Application for non-material amendment to Planning Permission 2024/62/91998/W

“Erection of special educational needs and disabilities school (use class F1), comprising educational buildings, roof mounted photo-voltaic panels, sensory garden spaces, multi-use games areas, landscaping, hardstanding areas, carparking, access with secure fencing and associated ancillary development”

Specifically, this application proposes non material amendment to drawings referenced in condition 2 (Plans and Specifications Schedule), condition 20 (lighting) and Condition 22 (Drainage).

Proposed Plan
(Scale 1:500)

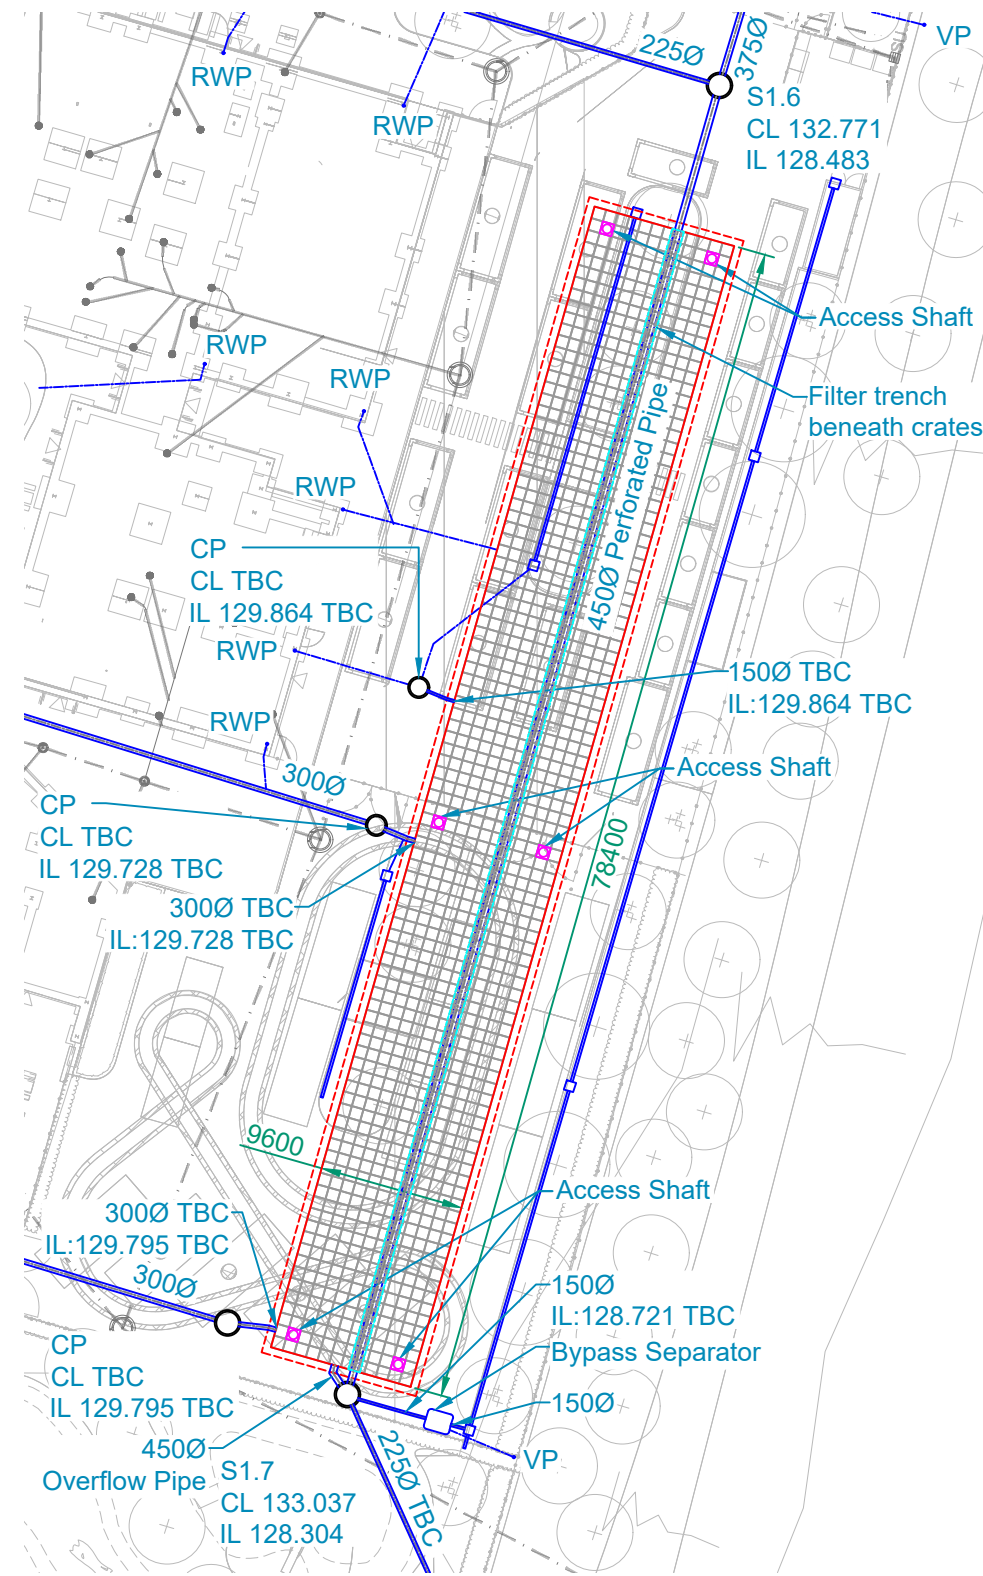
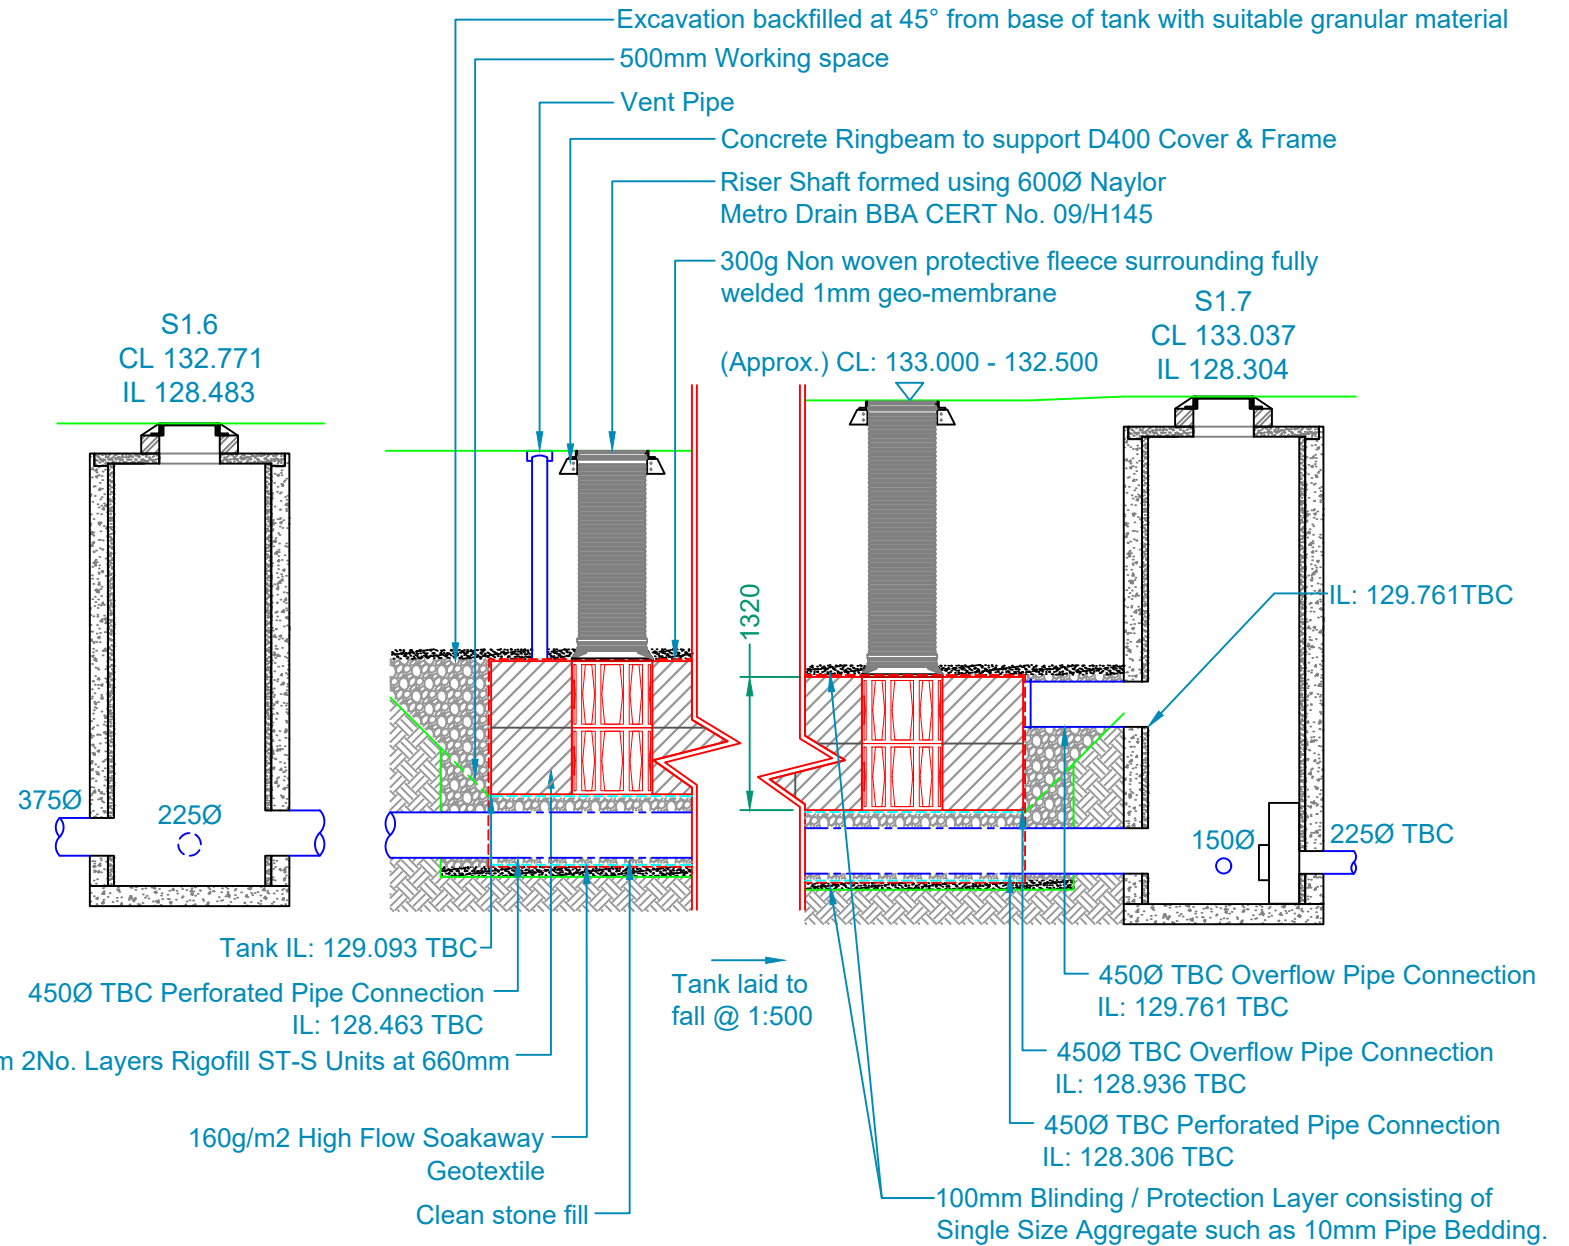
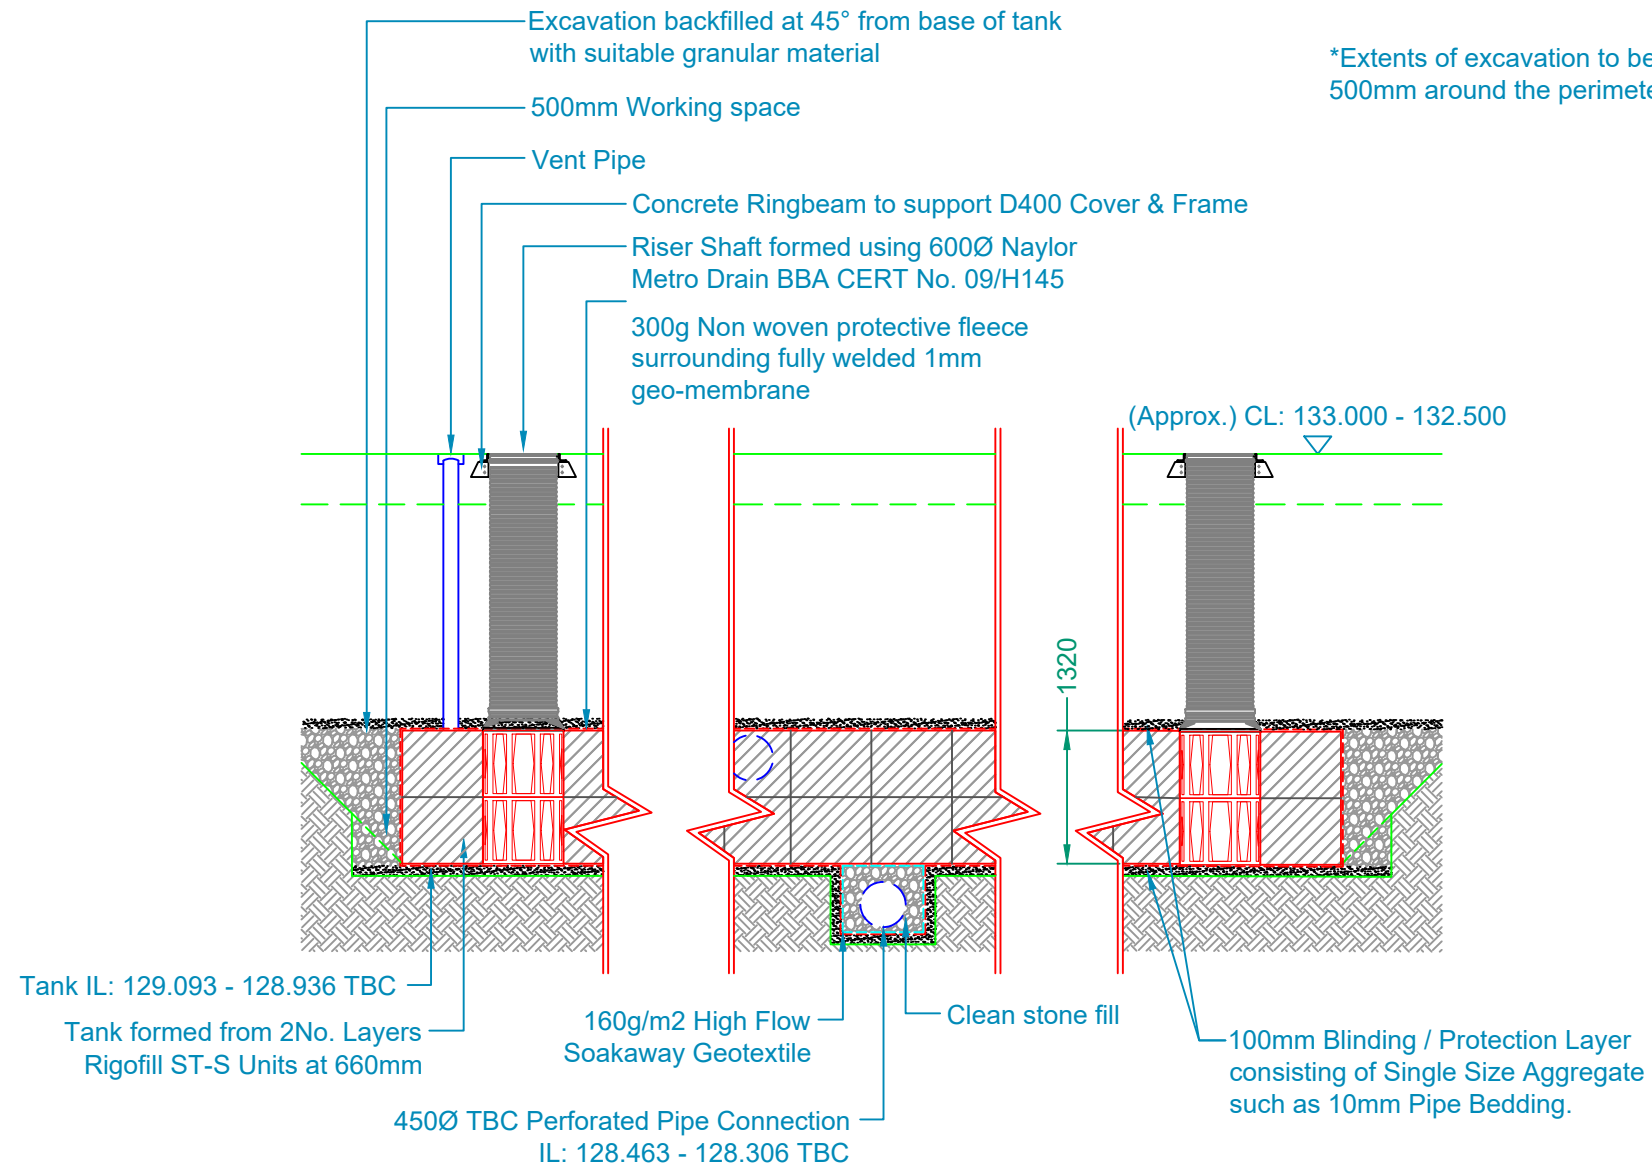
It is proposed to amend the drainage attenuation system, replacing the previously indicated Tubosider system with a modular attenuation system. The Lead Local Flood Authority has been consulted on this change through pre-application discussions

*“The development shall be carried out in accordance with the details shown on the submitted plan, “**NWSC-HEX-XX-XX-TN-C-0001-V01-Drainage Planning Technical Note**”, unless otherwise agreed in writing with the Local Planning Authority.”*
